KITTITAS COUNTY COMMUNITY DEVELOPMENT SERVICES

June 16, 2014

Subject: Final Planned Unit Development Application for the Ranch on Swauk Creek

Cut Fill Haul Sta- Yds	85+00	86+00	87+00	88+00	89+00	90+00	91+00	92+00	93+00	94+00	95+00	96+00	97+00	98+00
		+75 3975 2748 20827									+00 3975 2748 20827

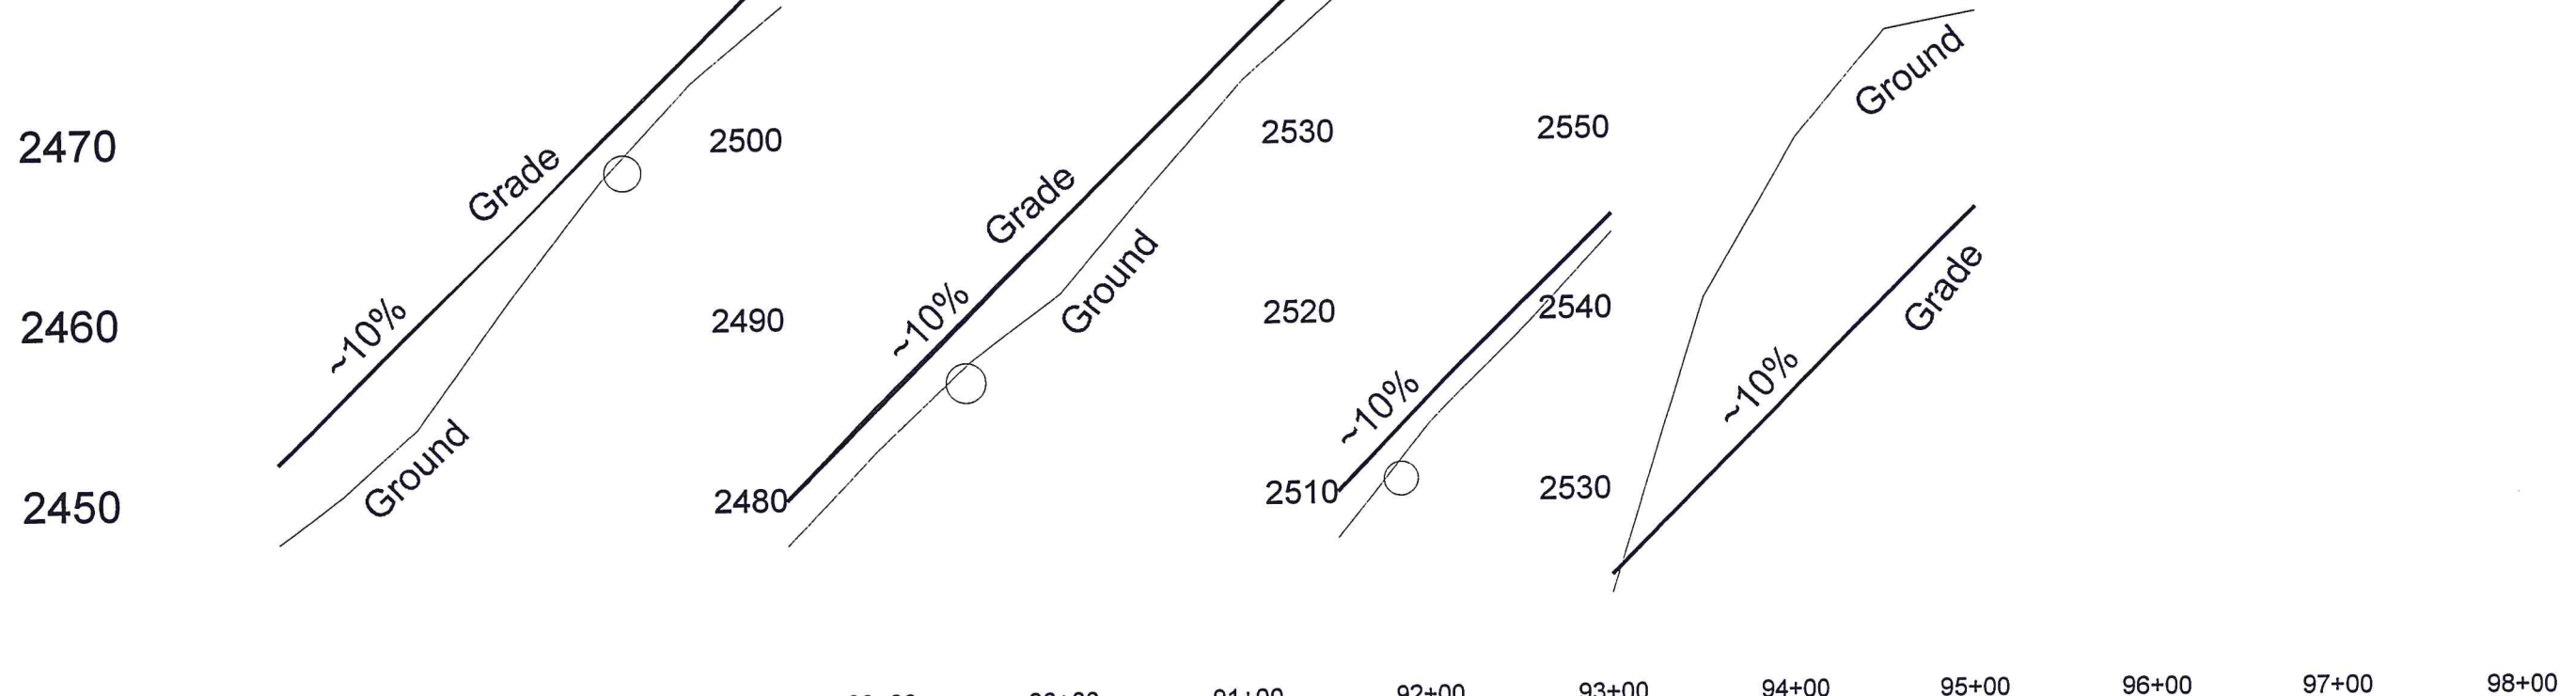
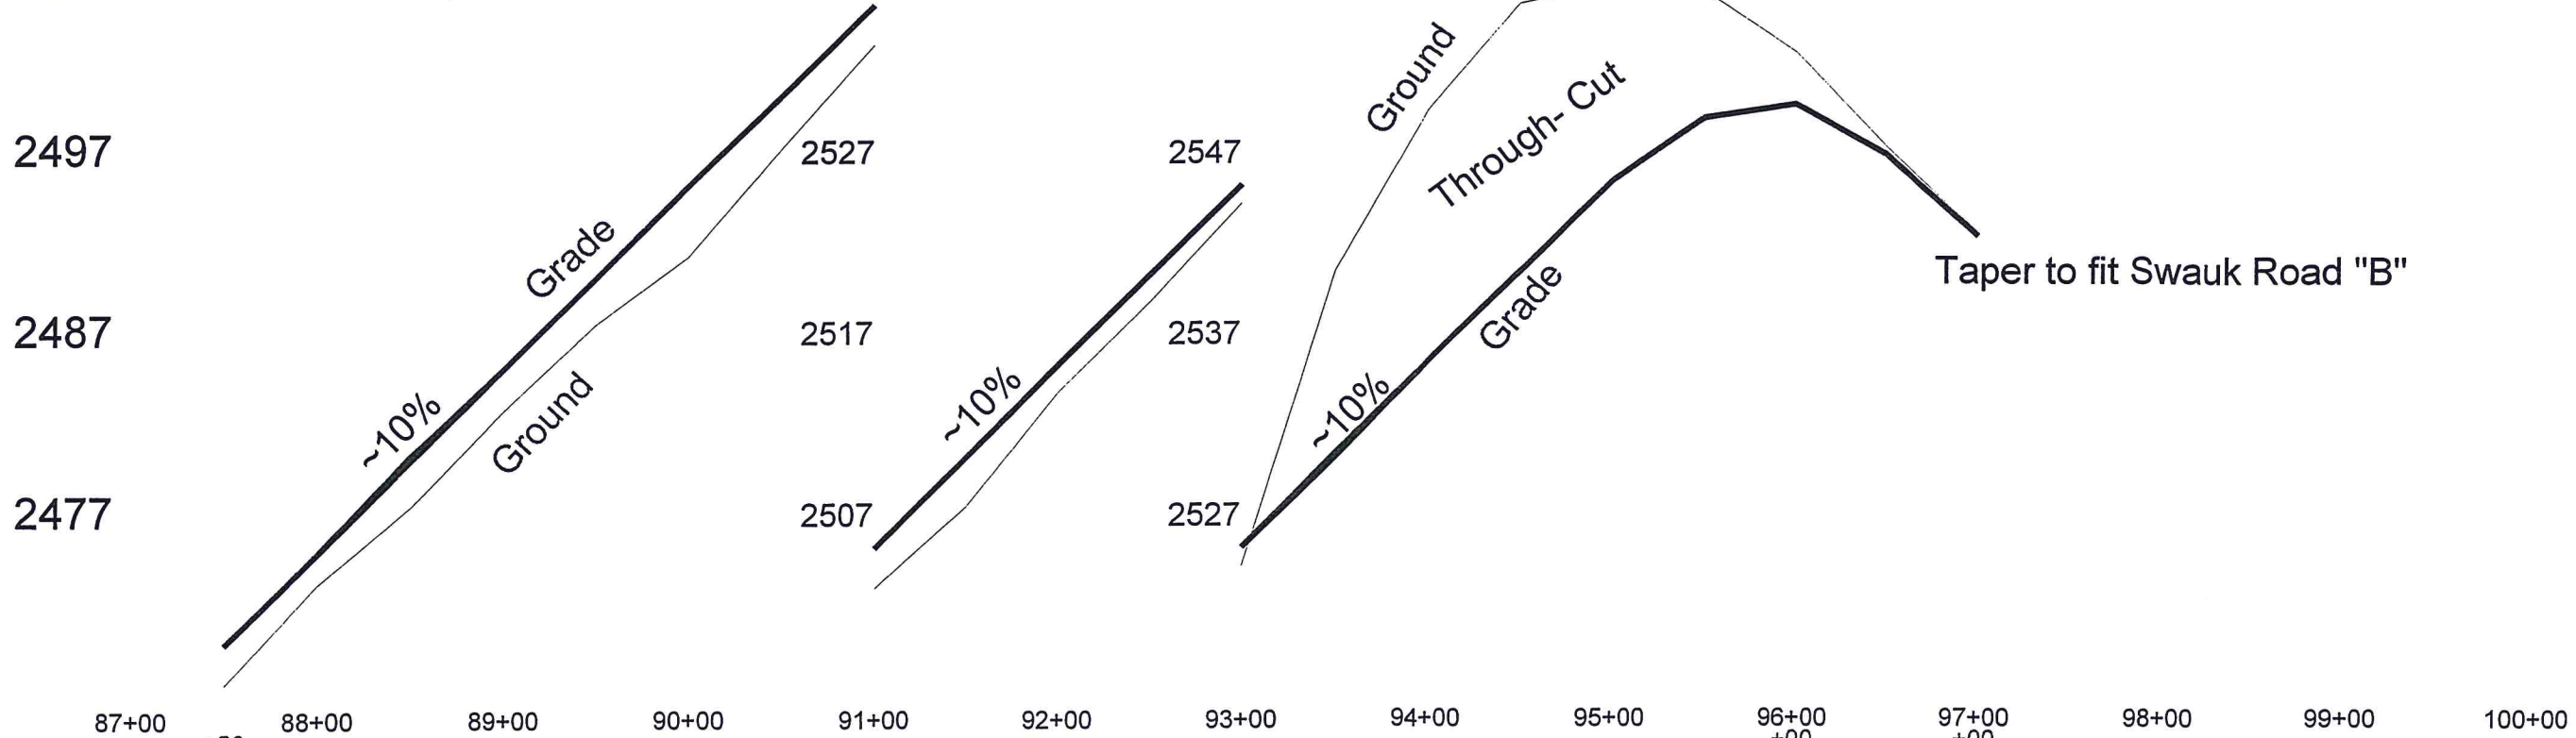
Attachment E addresses road grading but it does not appear to cover all three phases of the PUD nor does it appear on the main map required at a. At a minimum, all proposed roadways, utilities and preliminary grades for either Phase 1 (if seeking phased approval) or Phases 1-3 need to be shown on the map.

Attachment A and E are referenced in the application as being responsive to this criteria. However Attachment A is not a map, it is a narrative only. Attachment E includes roadway surfacing cost estimates but it is not clear that this covers more than Division 1 Phase 1. Further, the paved area needs to be shown on the overall PUD map exhibit, or if seeking phased approval, on the Phase 1 map exhibit.

Same as above, it is not clear that the roadways depicted in Attachment E cover only Phase 1, Division 1 or if they are intended to serve all of Phase 1's 81 lots. This needs to be shown on the required map exhibit.

ATTACHMENT B

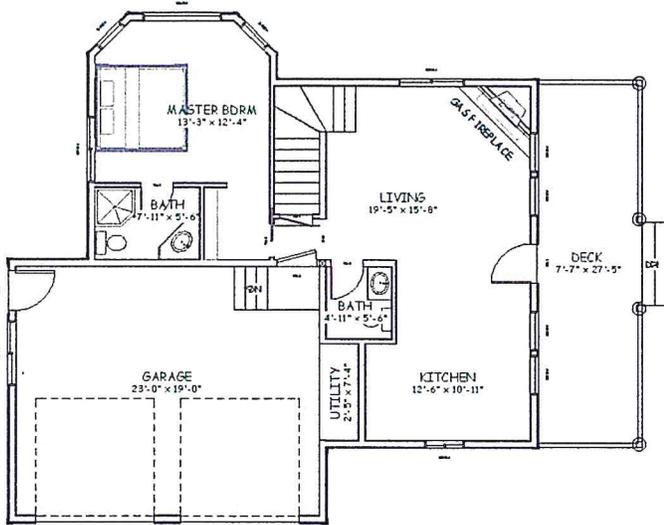
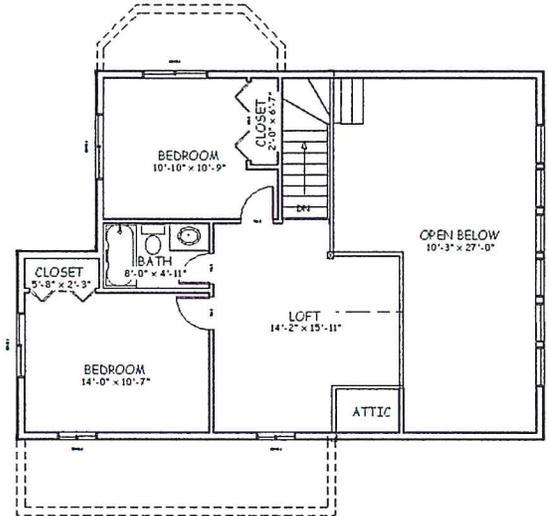
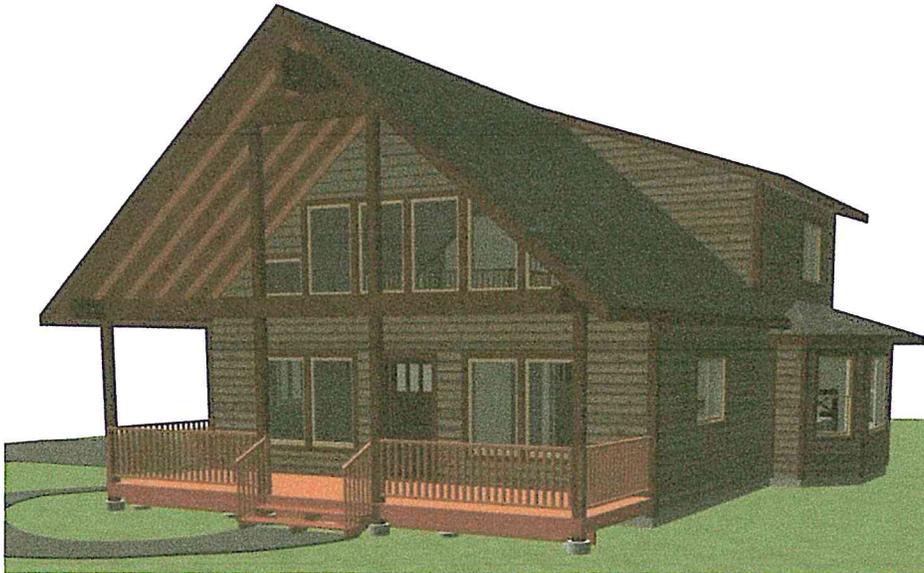
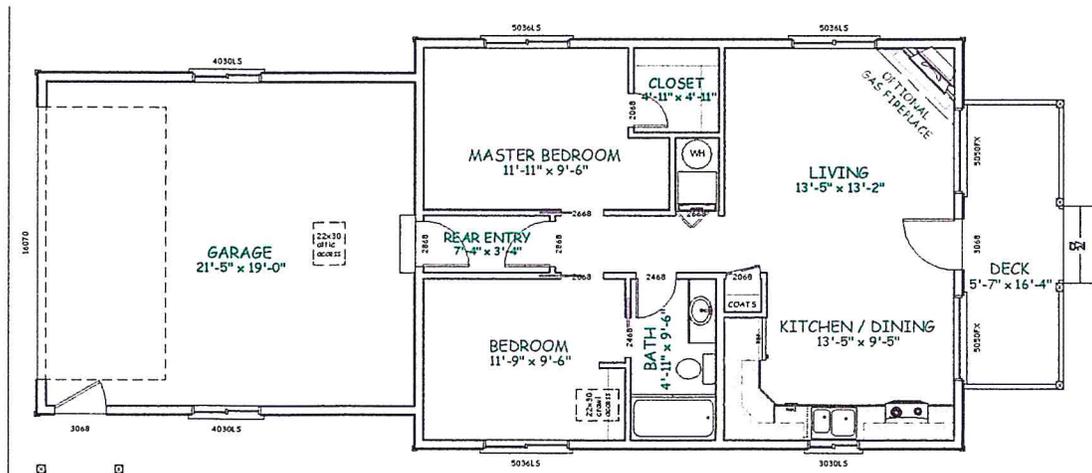
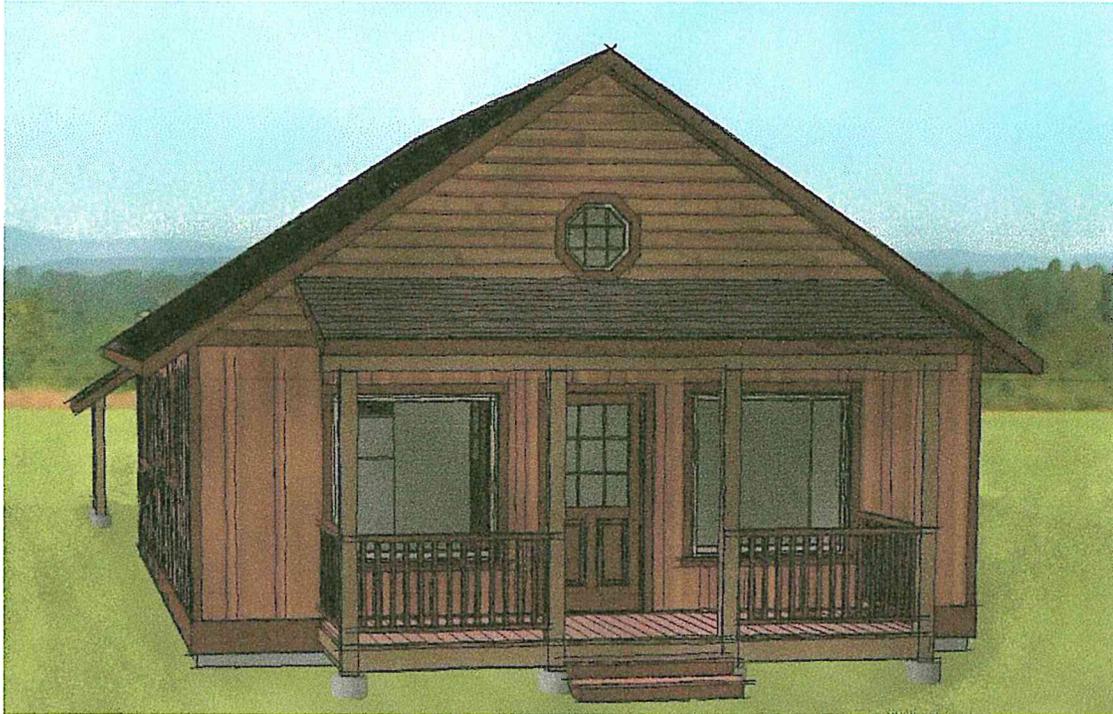
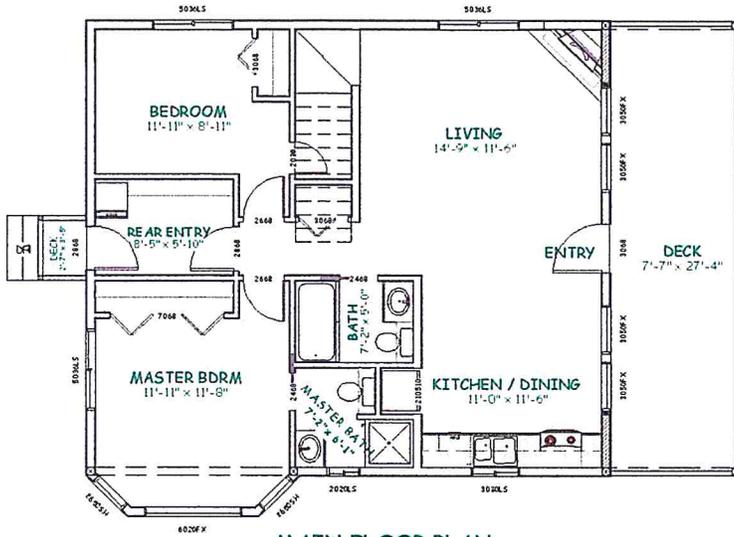
Attachments B and C depict the range of building types proposed but only for the 14 lots in Division 1. What is not showing is the proposed buildings for all of Phase 1 (if seeking phased approval) or all of Phases 1-3.

Attachment B which shows typical housing styles seems to address this criterion. If additional housing styles are proposed throughout other Phases, these should be provided at Attachment B as well.
